WEST SUSSEX COUNTY COUNCIL CONSULTATION

TO:	Arun District Council FAO: Rhiannon Lloyd
FROM:	WSSC – Highways Authority
DATE:	27 March 2026
LOCATION:	5 High Street Bognor Regis PO211RQ
SUBJECT:	BR/31/26/PD Application for prior approval under schedule 2, Part 3, Class MA for proposed change of use from commercial, business and service (Use Class E) to 3 No. Dwellinghouses (Use class C3).
DATE OF SITE VISIT:	n/a
RECOMMENDATION:	Advice

Drawing
Proposed floor plans with dims

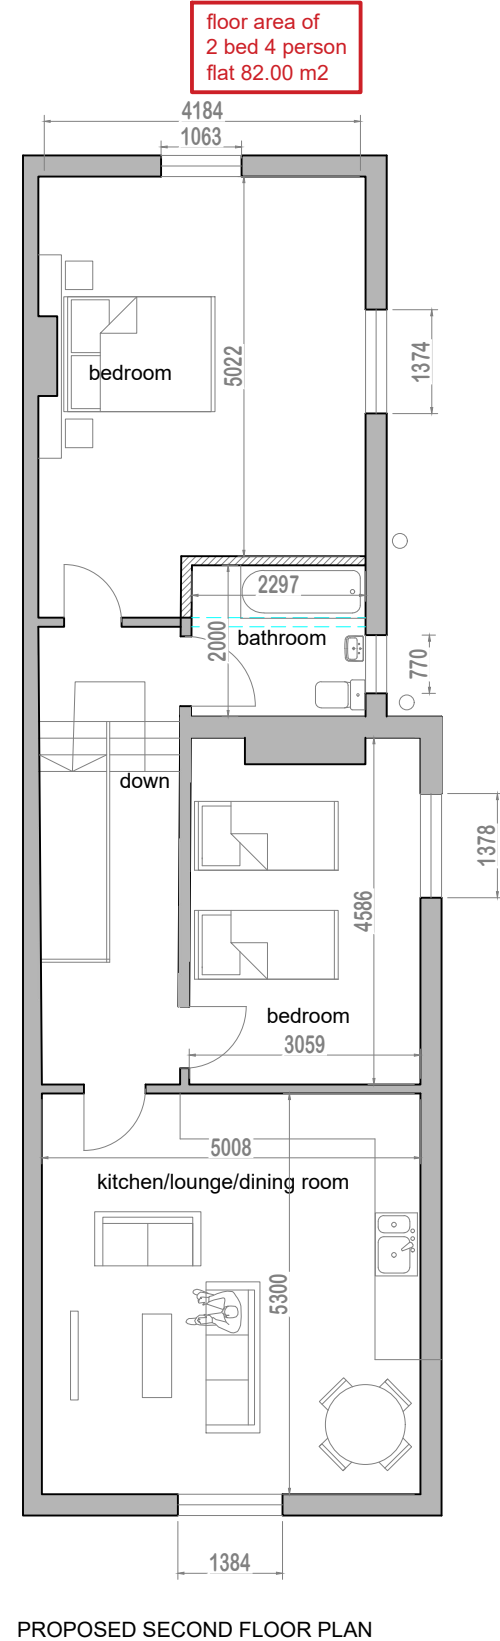
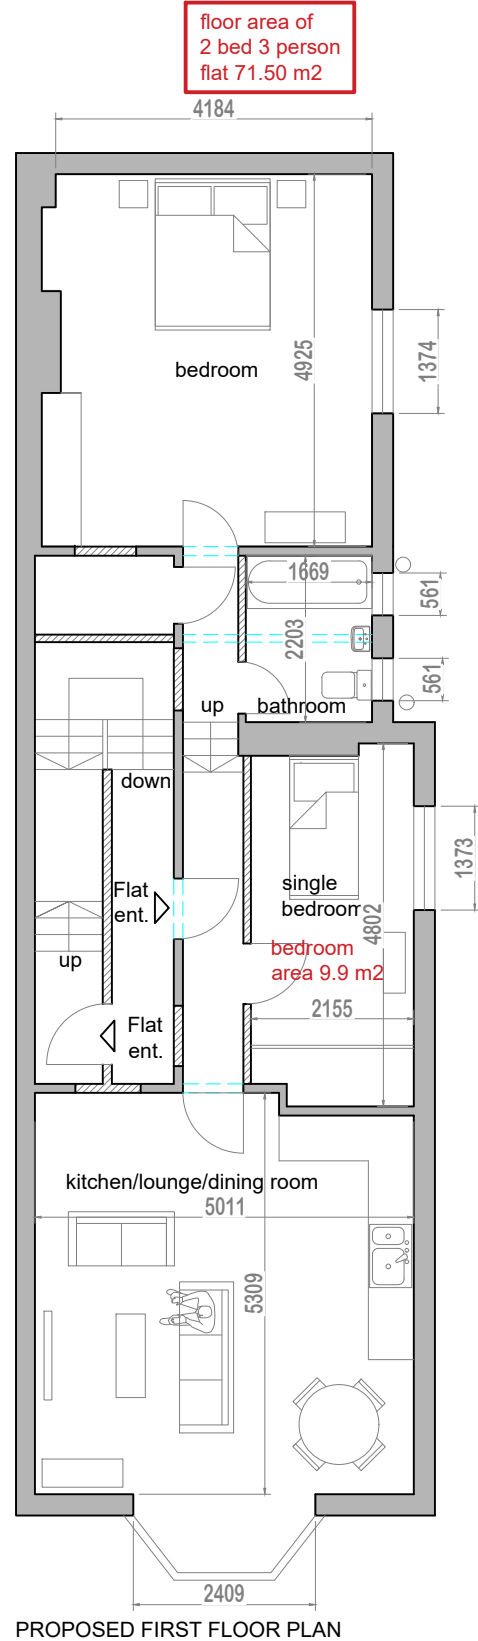
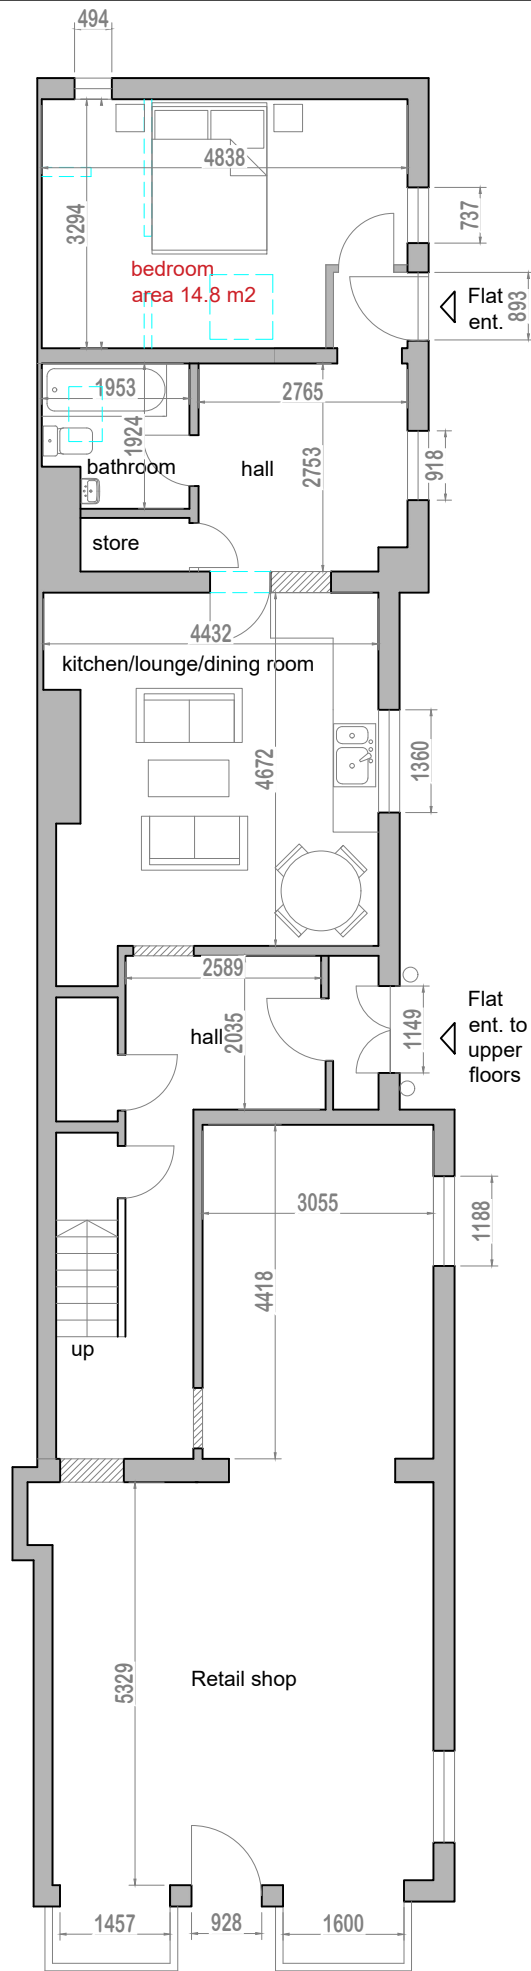
The site currently operates as an optician (E class use) on all three floors. The proposal will retain E class use on part of the ground floor, with the rear of the ground floor and the first and second floor subject to change of use to residential, for 1 x 1-bed flat and 2 x 2-bed flats. The site does not benefit from an existing vehicular access or off-street parking, and this application does not propose to alter that arrangement. As such, the proposal would result in a nil parking provision.

The WSSC Car Parking Demand Calculator indicates that a development of this size in this location would require four car parking spaces, however weight is given to the fact that the site is located within the town centre, within immediate proximity of shops and transport links. The LPA are advised that they may wish to secure cycle parking provision, to promote sustainable travel.
